**M54 to M6 Link Road  
TR010054**

**8.19 Applicant Responses to Examining  
Authority's Second Written Questions,  
Representations Made at Deadlines 2, 3  
and 3a and Matters Raised During  
Hearings in December 2020**

**Applicant Response to ExA's Second Written Questions, Representations  
Made at Deadlines 2, 3 and 3a and Responses to Issues Raised at  
Hearings in December 2020**

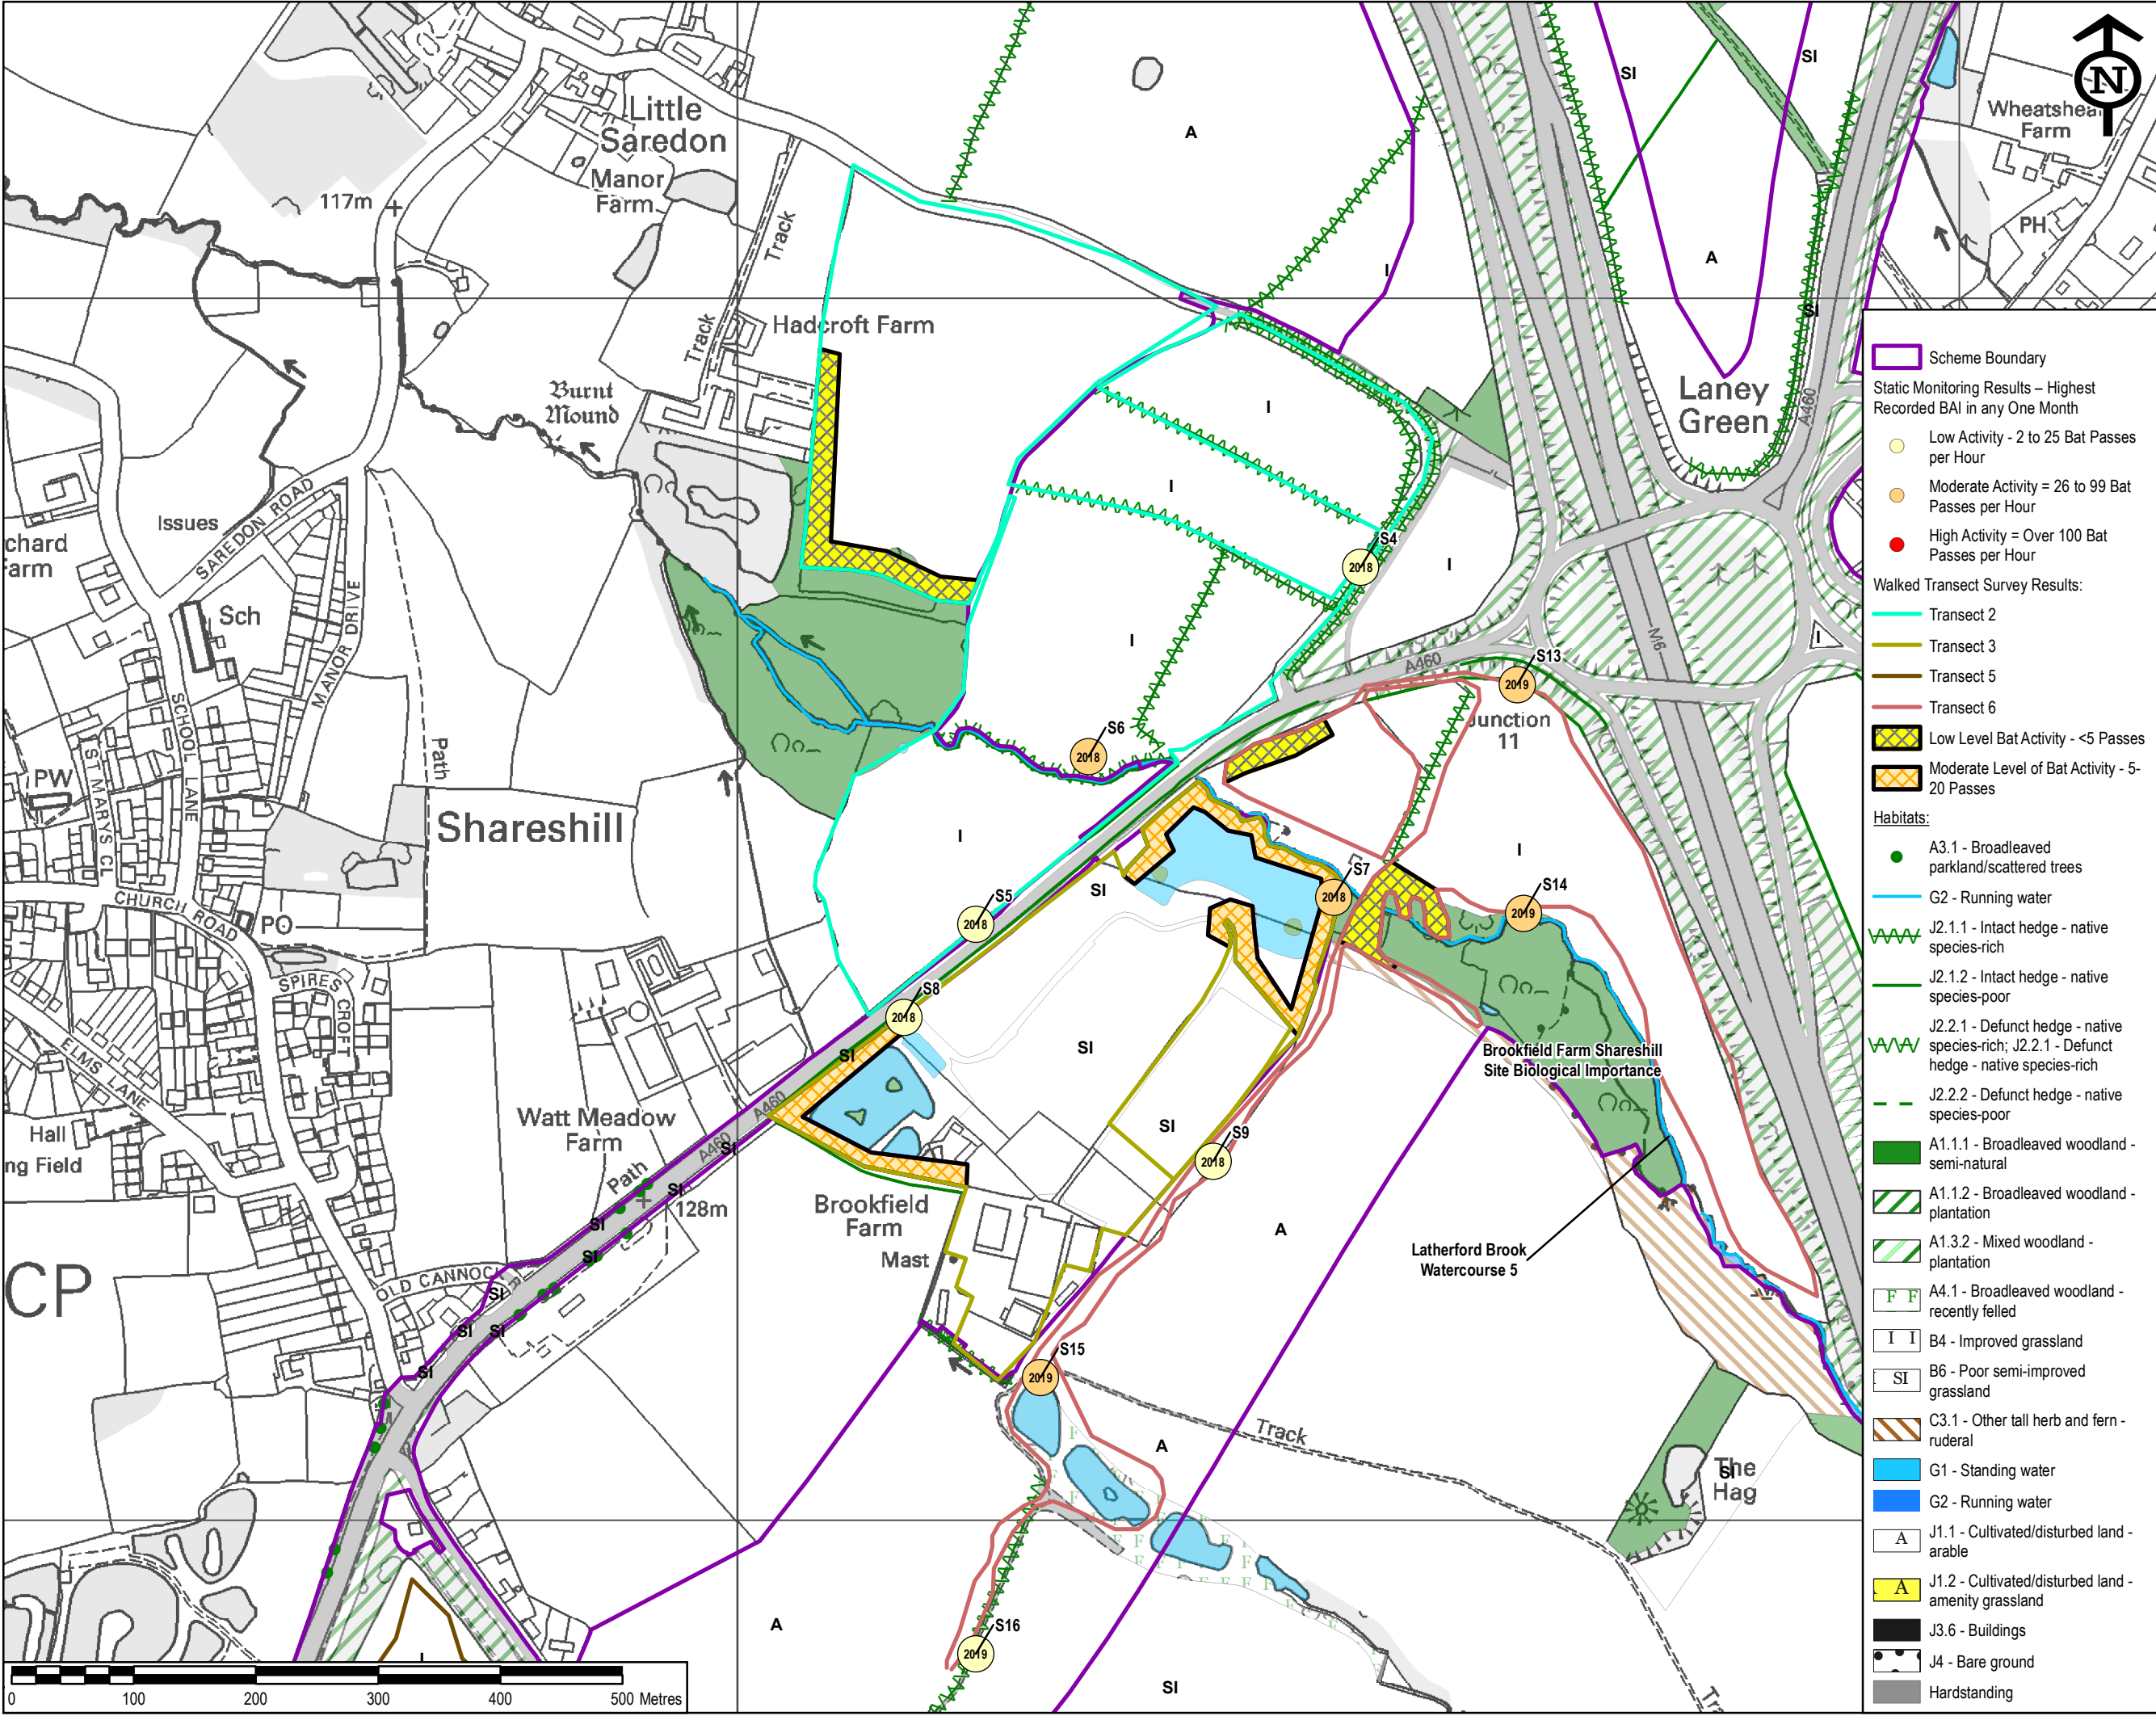
| 2.3.5 | The Applicant                | <b>ES Figure 8.18</b><br>The Guide to the Application [REP3-002/REP3-003] indicates that Environmental Statement Figure 8.18: Bat Baseline - Transect Activity Survey Results (2018 and 2019) [APP-122] has six sheets. However, the submitted document only has three sheets. Could this be clarified?   | This is a minor inconsistency in The Guide to the Application [REP3-002/REP3-003]. Figure 8.18: Bat Baseline - Transect Activity Survey Results (2018 and 2019) [APP-122] should consist of three sheets, not six. The Guide to the Application issued at Deadline 4 has been corrected to reflect this.  |
